CITY OF ALBUQUERQUE

October 2, 2013

**Re: Bruckner's Truck Sales,
8101 Daytona Rd NW
Request for 30-day Temporary C.O. –Accepted
Engineer's Stamp dated: 9-20-12, (J09D021)
Certification dated: 10-1-13**

18" SD HEAD WALL - SECTION A-A

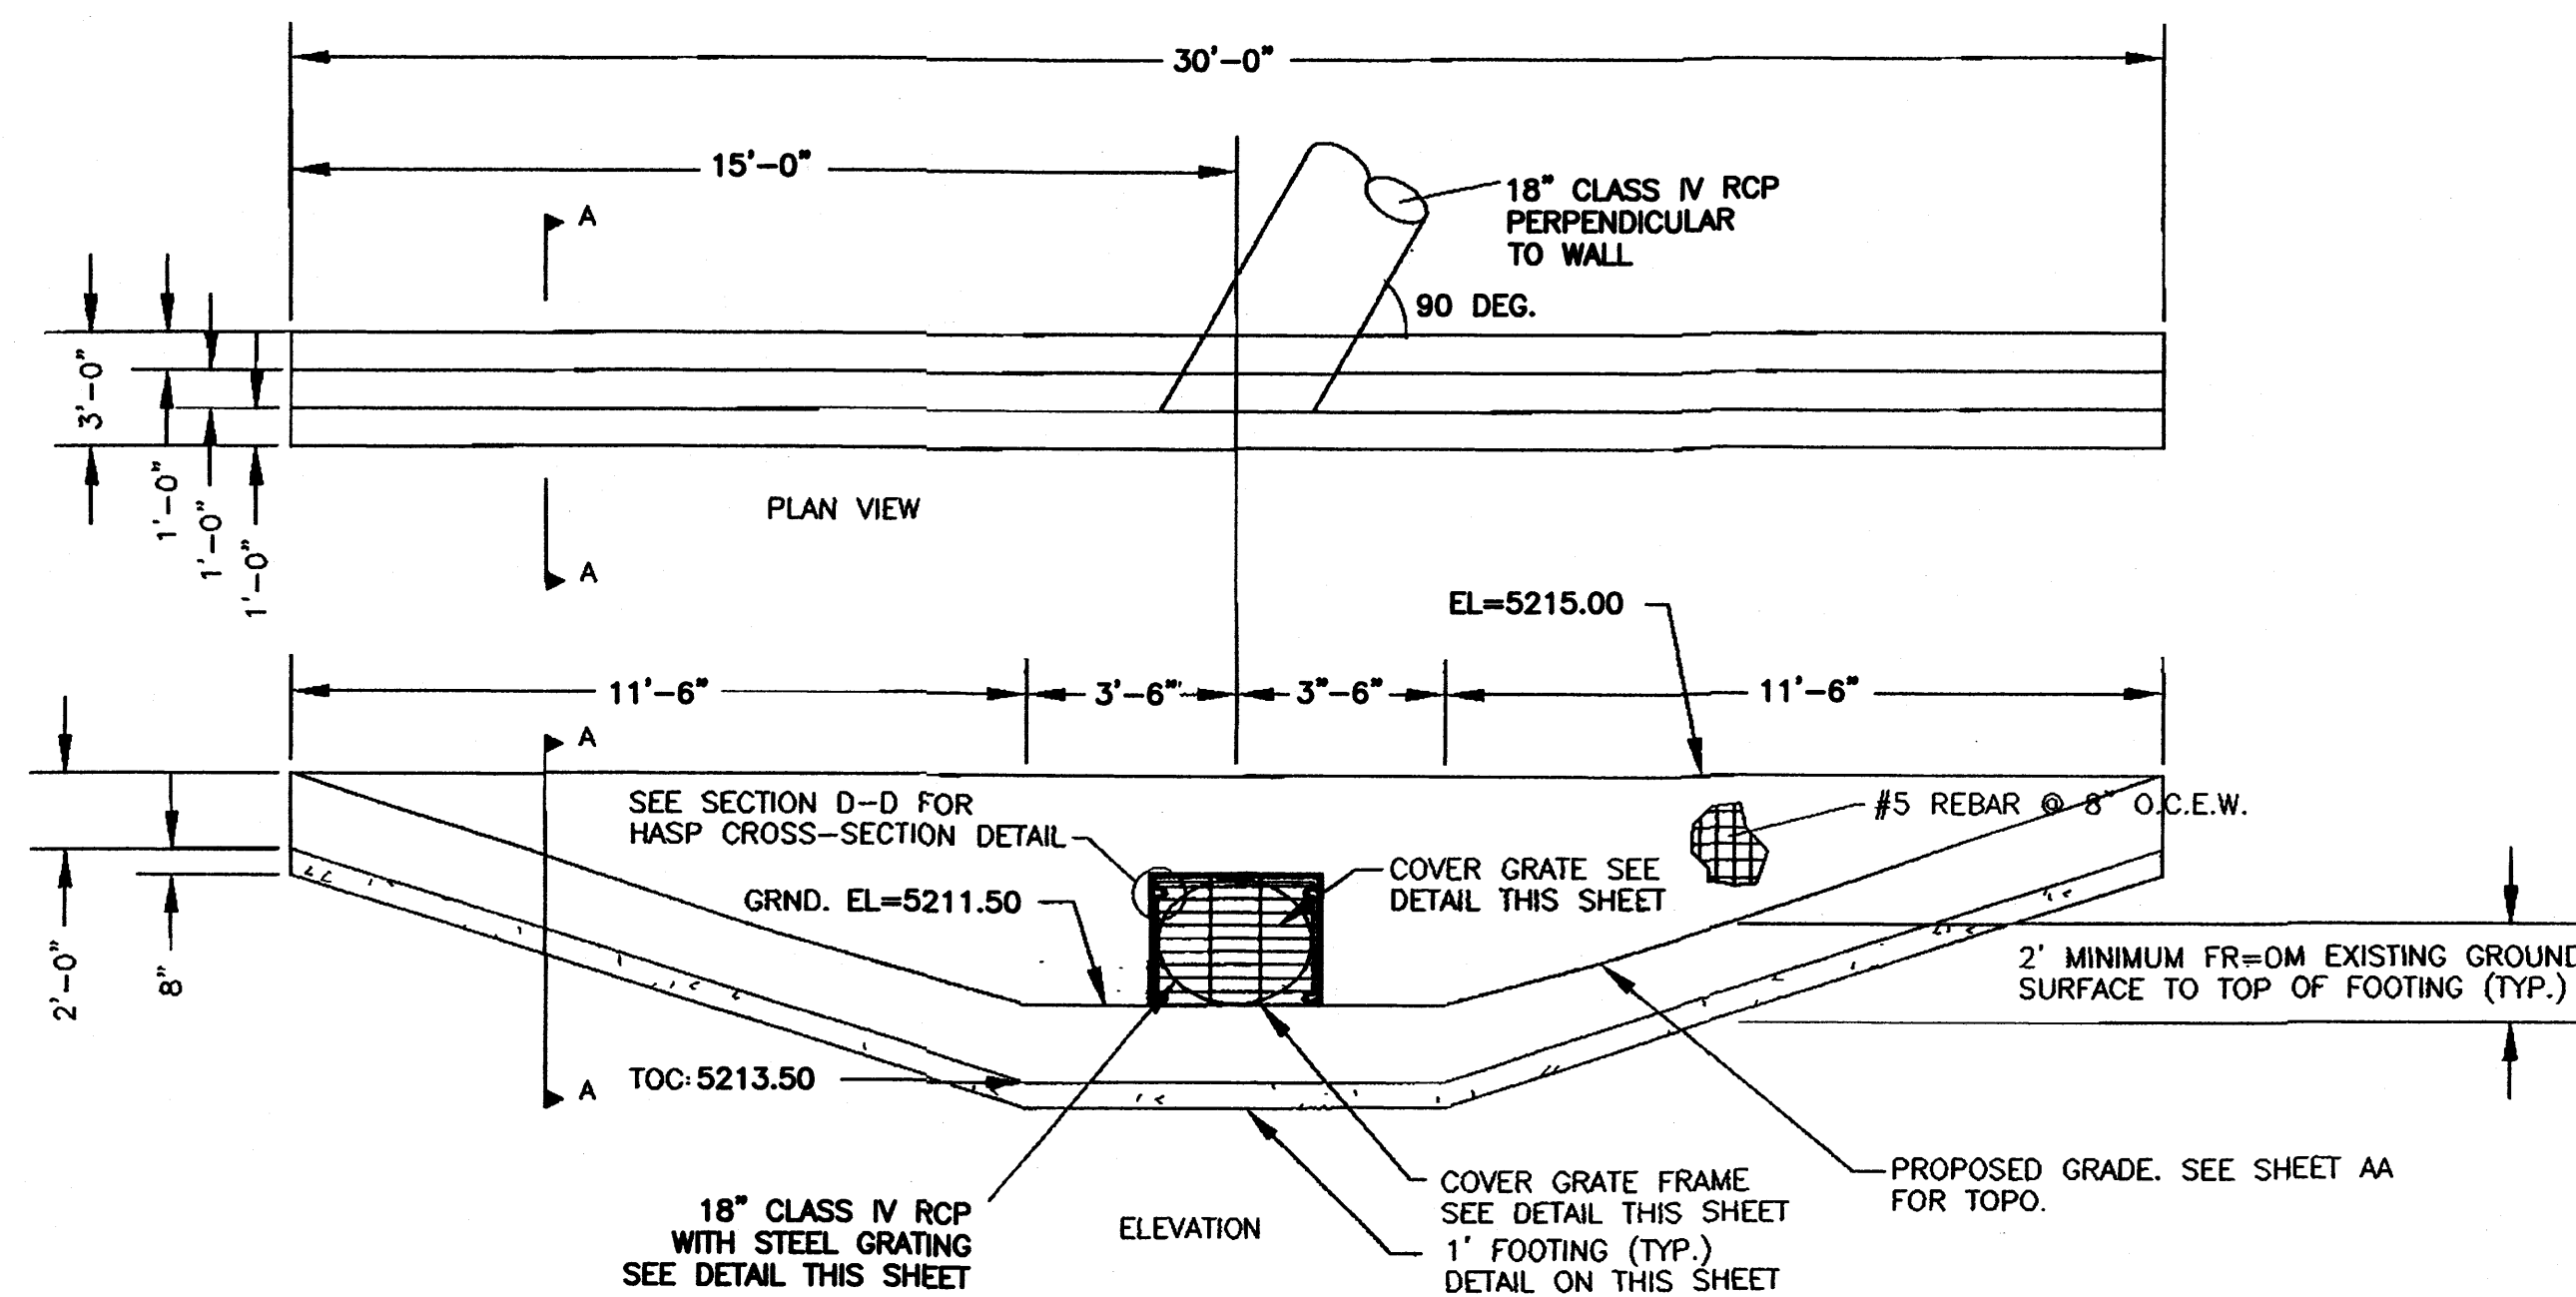
5. The 18" SD Headwall-Section A-A shown on sheet C8 was not visible at the Offsite Basin I40-3 location.
